Response to Comments

3845 Cambrian Road

**RE: Response to Comments
3845 Cambrian Road
Site Plan Control (D07-12-23-0058)**

1 SITE PLAN
A001 1:400

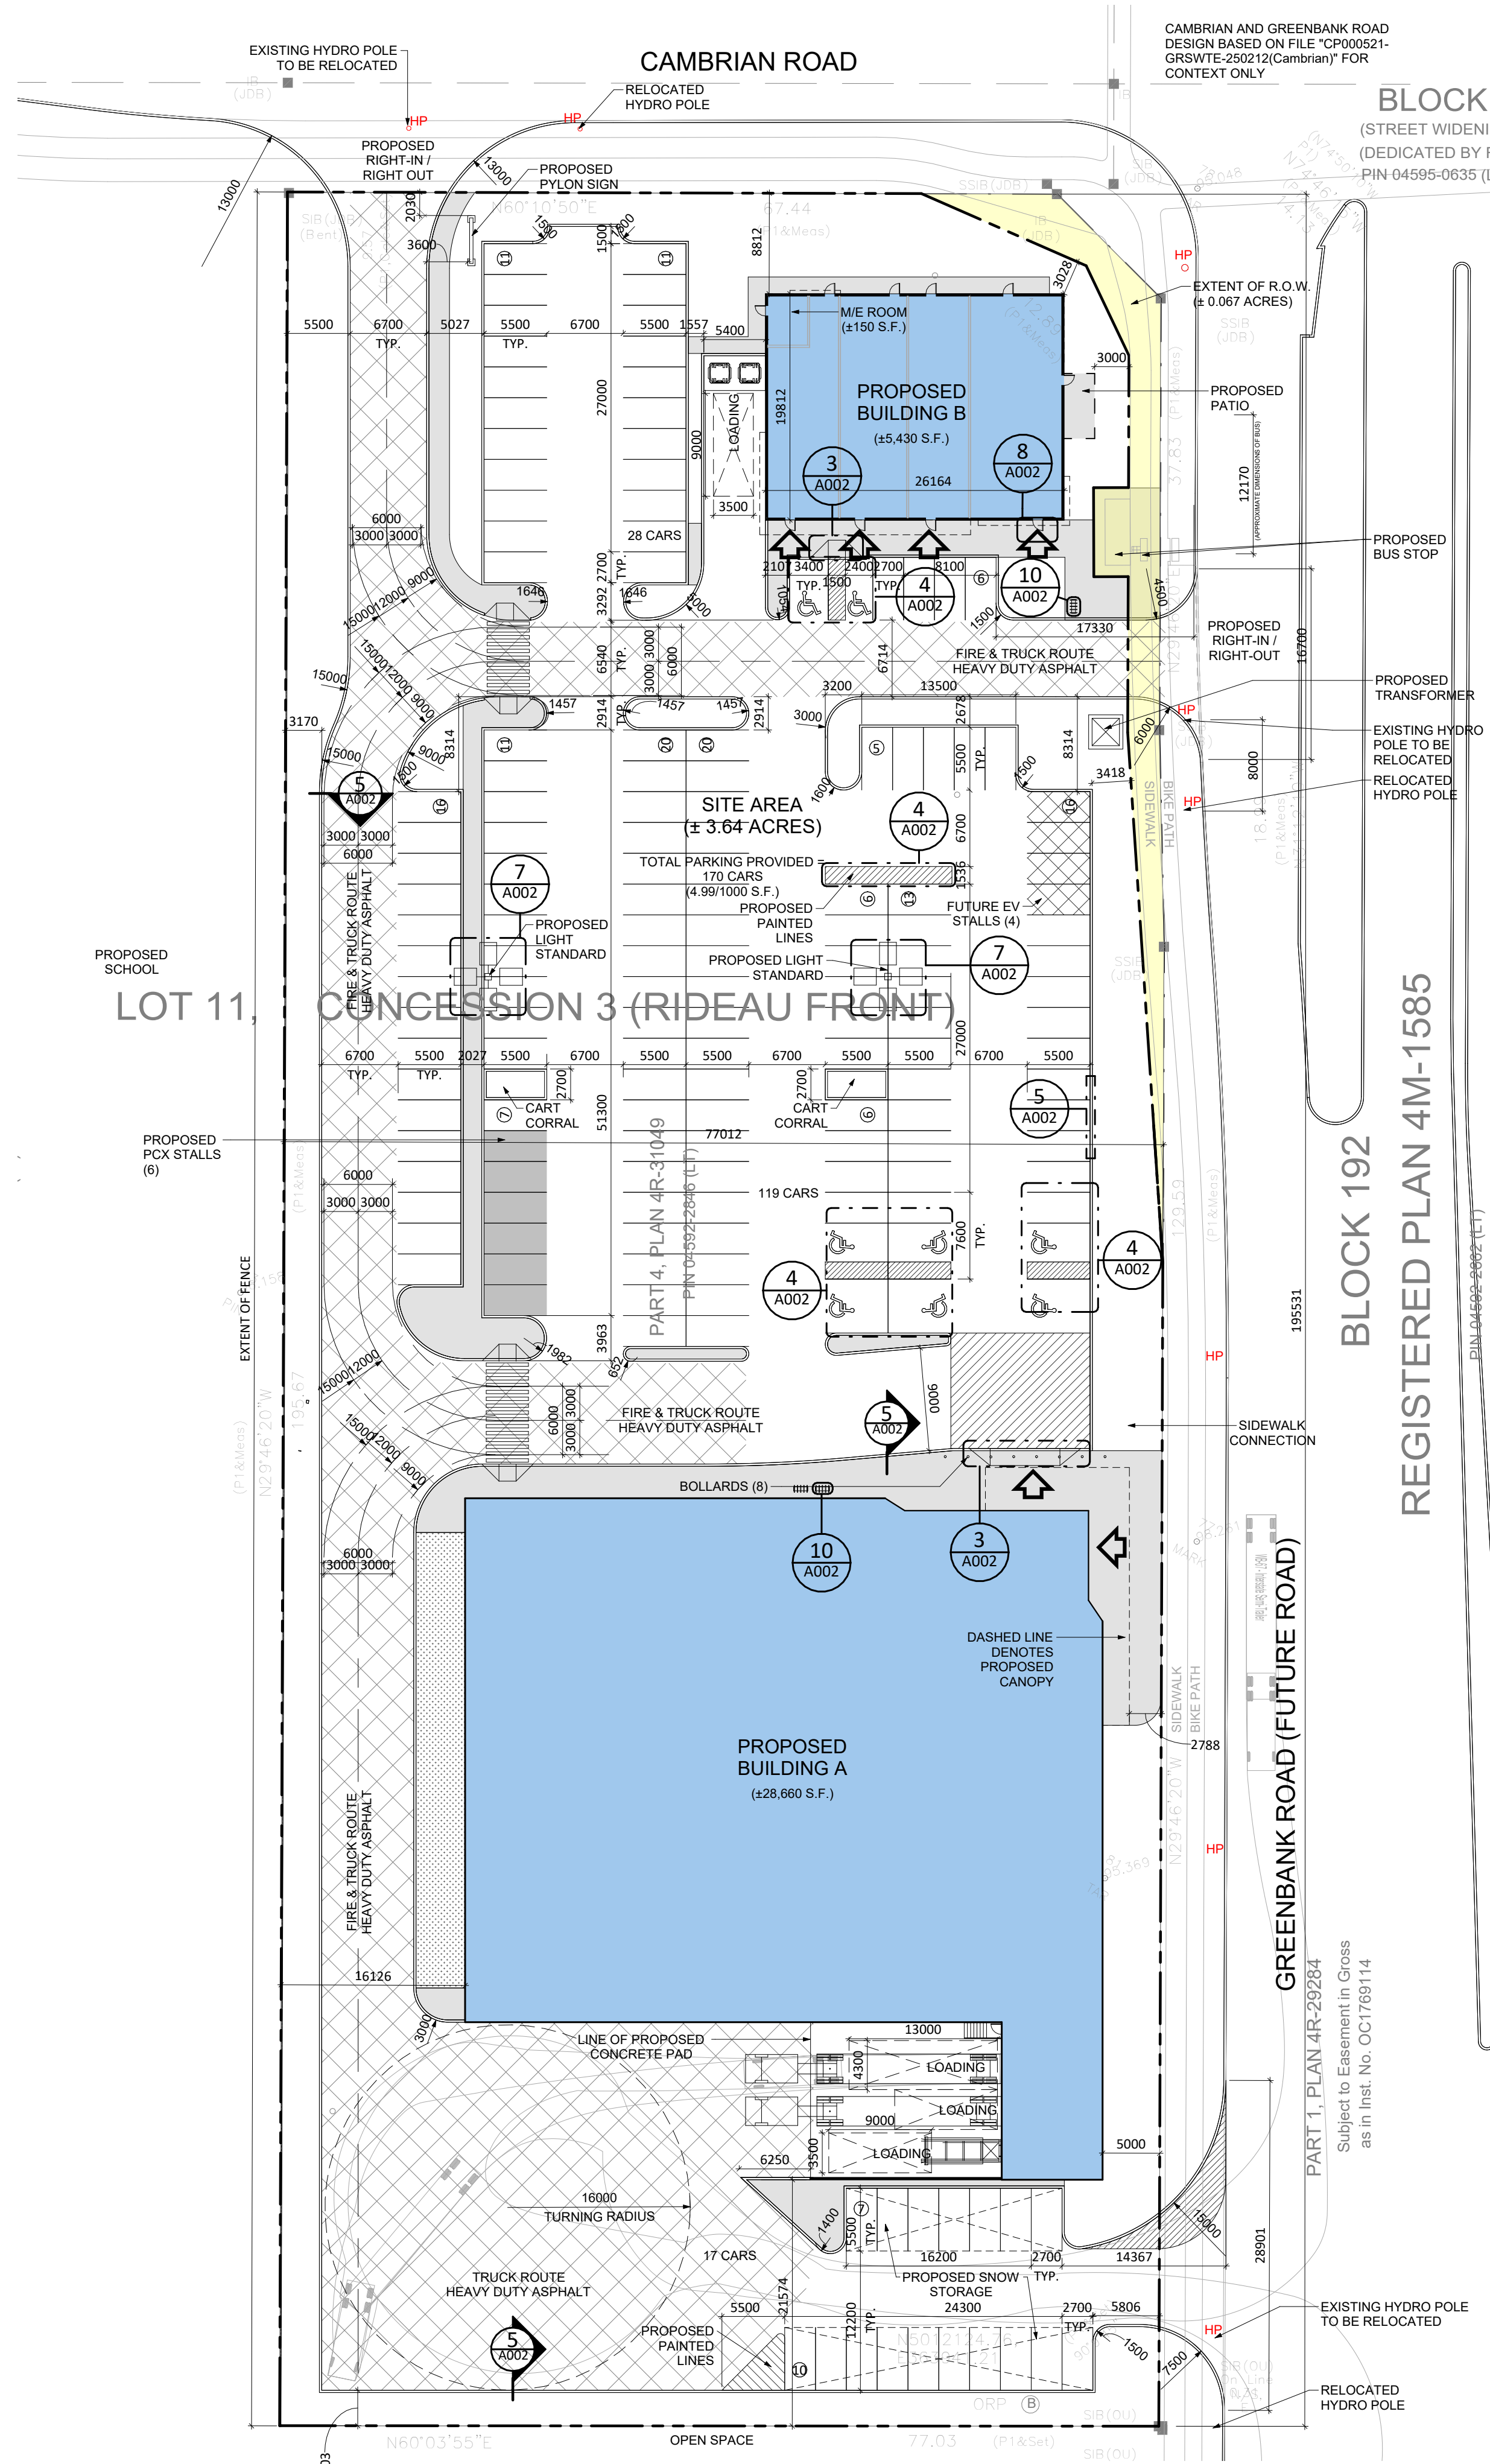
5.2. Provide a clear pedestrian connection from Cambrian Road through the site. Refer to the screenshots below as examples:

Response: North-south pathway connection provided. Refer to Site Plan drawing A001
